Rezoning Transportation Analysis
Petition Number: Insert Zoning Petition #2022-031
General Location Identifier: 19310302

Revision Log:

Date	Description
07-26-22	First Review (TM)
08-23-22	Second Review (WB)

Transportation Summary

RZ-1

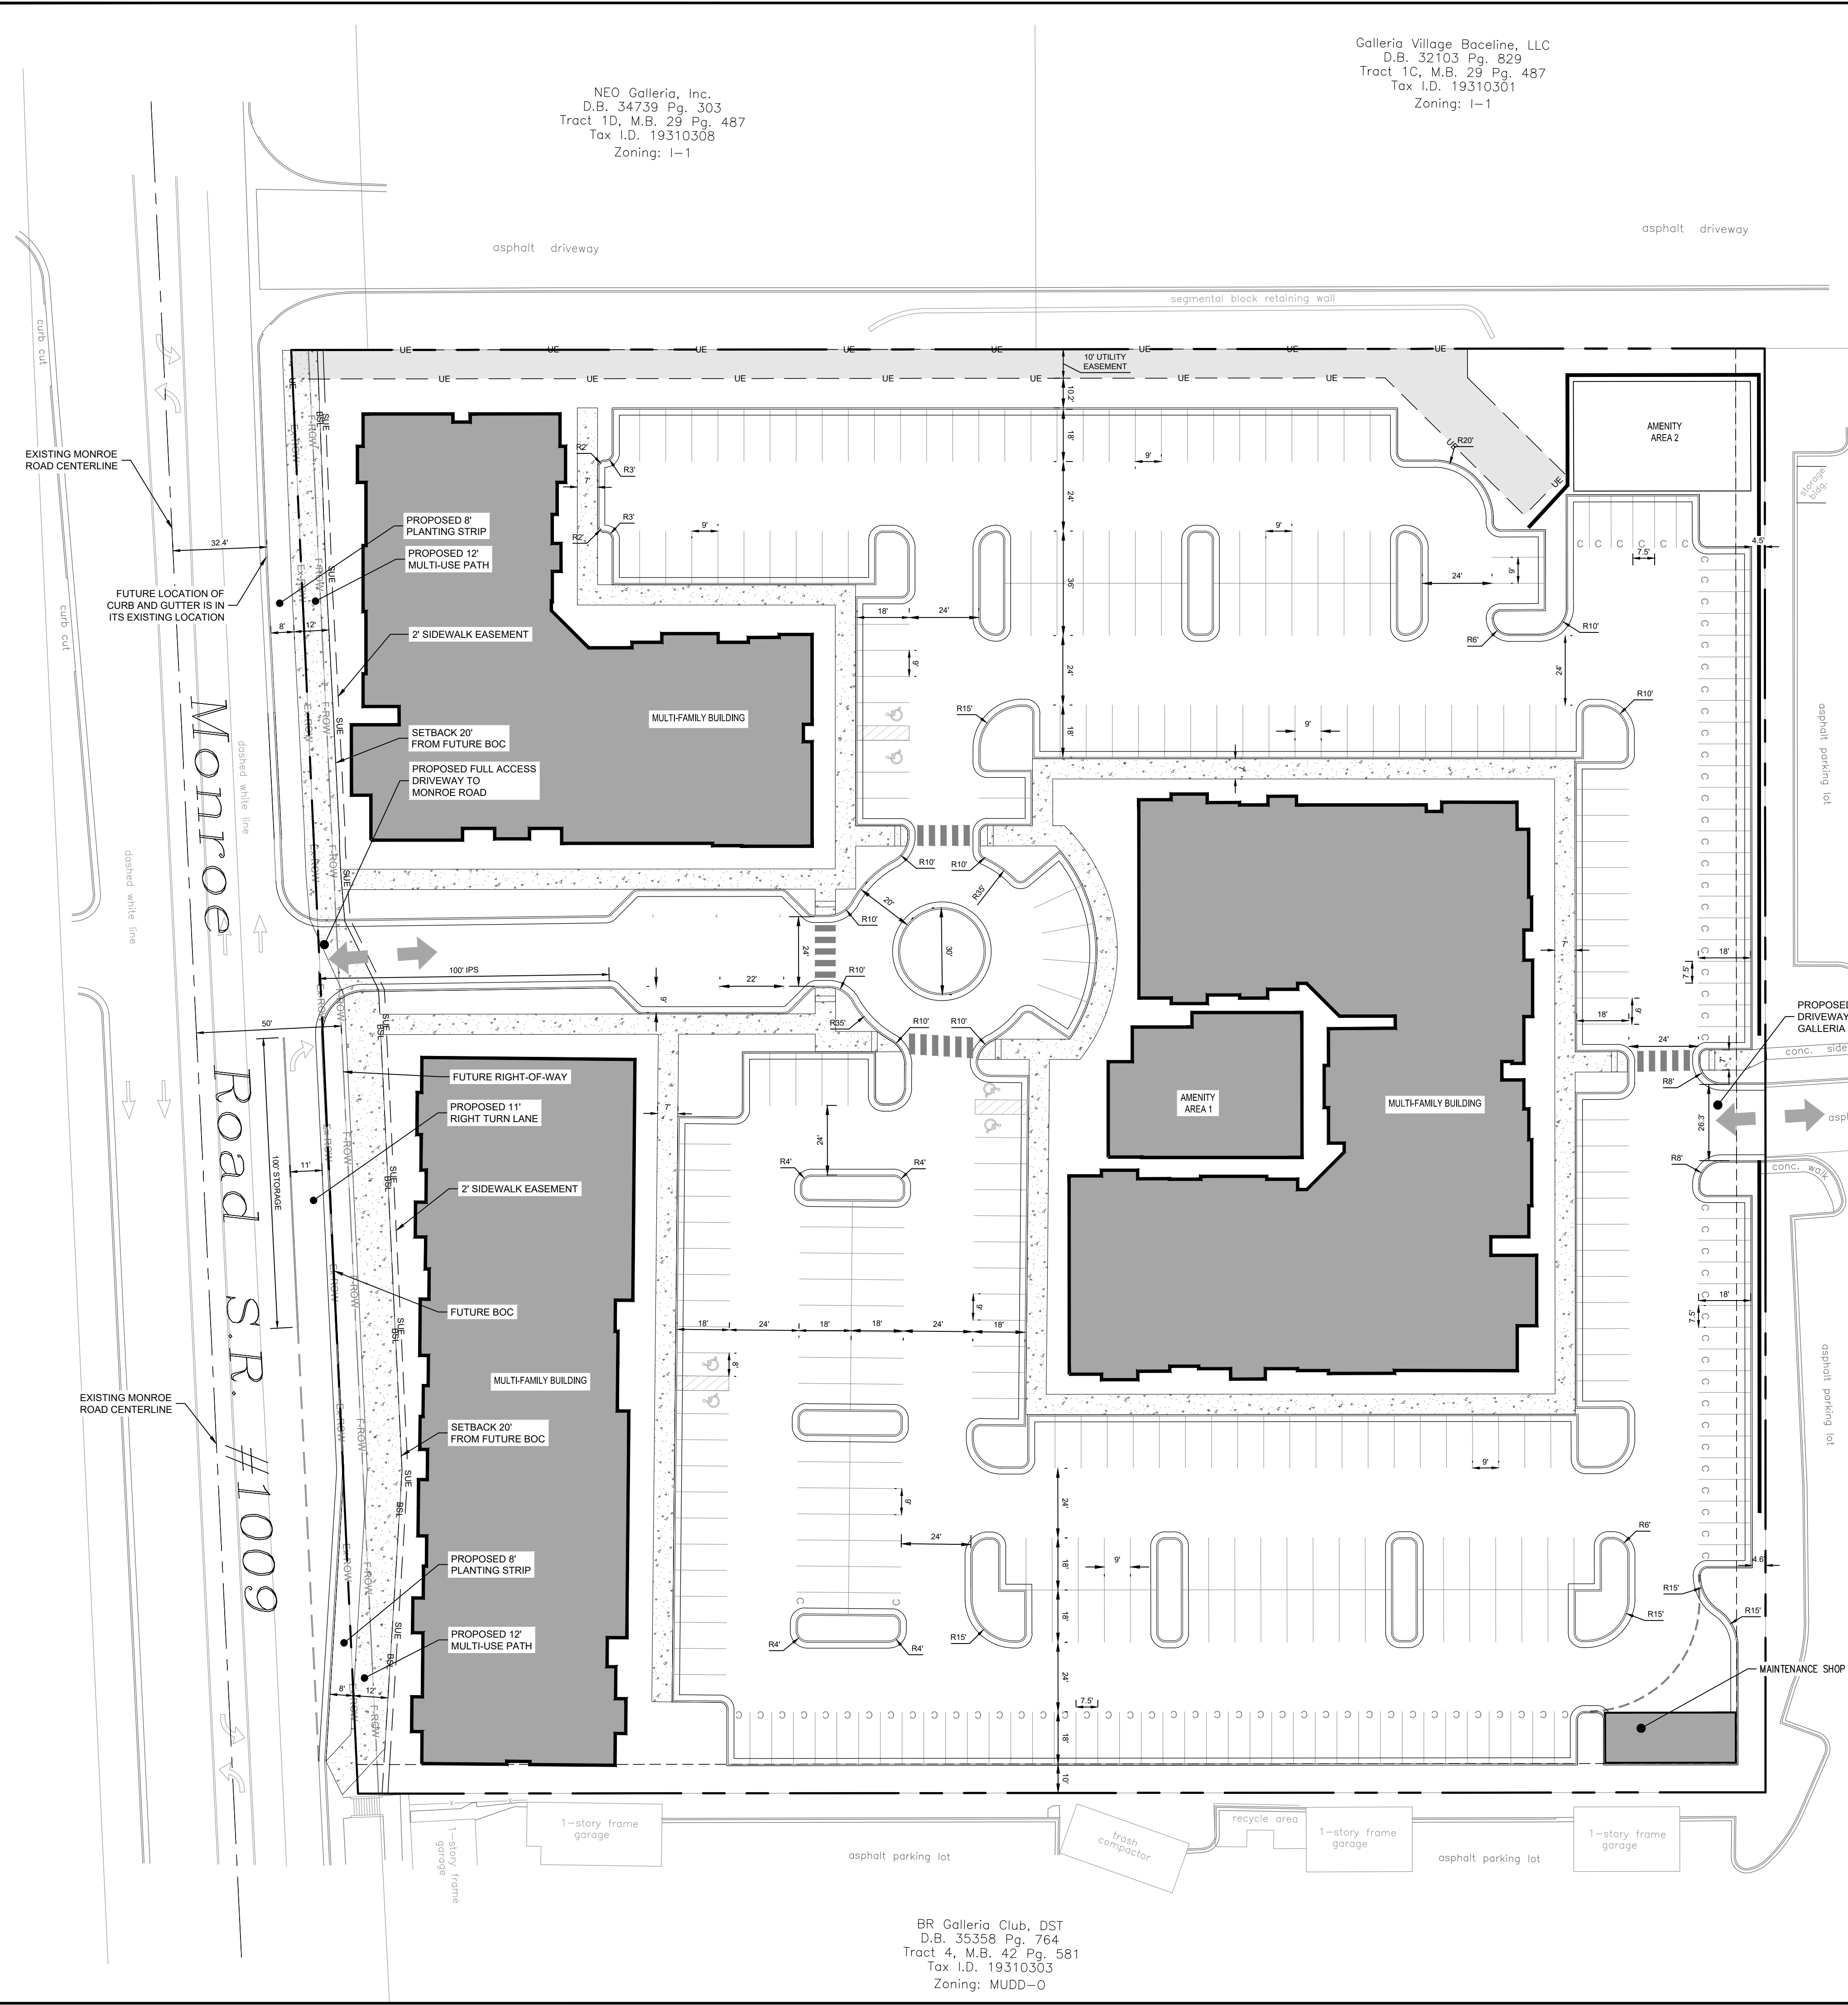
Site plan revisions are requested to commit to constructing a private street connection from Monroe Road to Galleria Club Lane. Further details are listed below.

- CDOT REQUEST:** Revise site plan and conditional note(s) to provide a private street connecting Galleria Club Lane to Monroe Road.
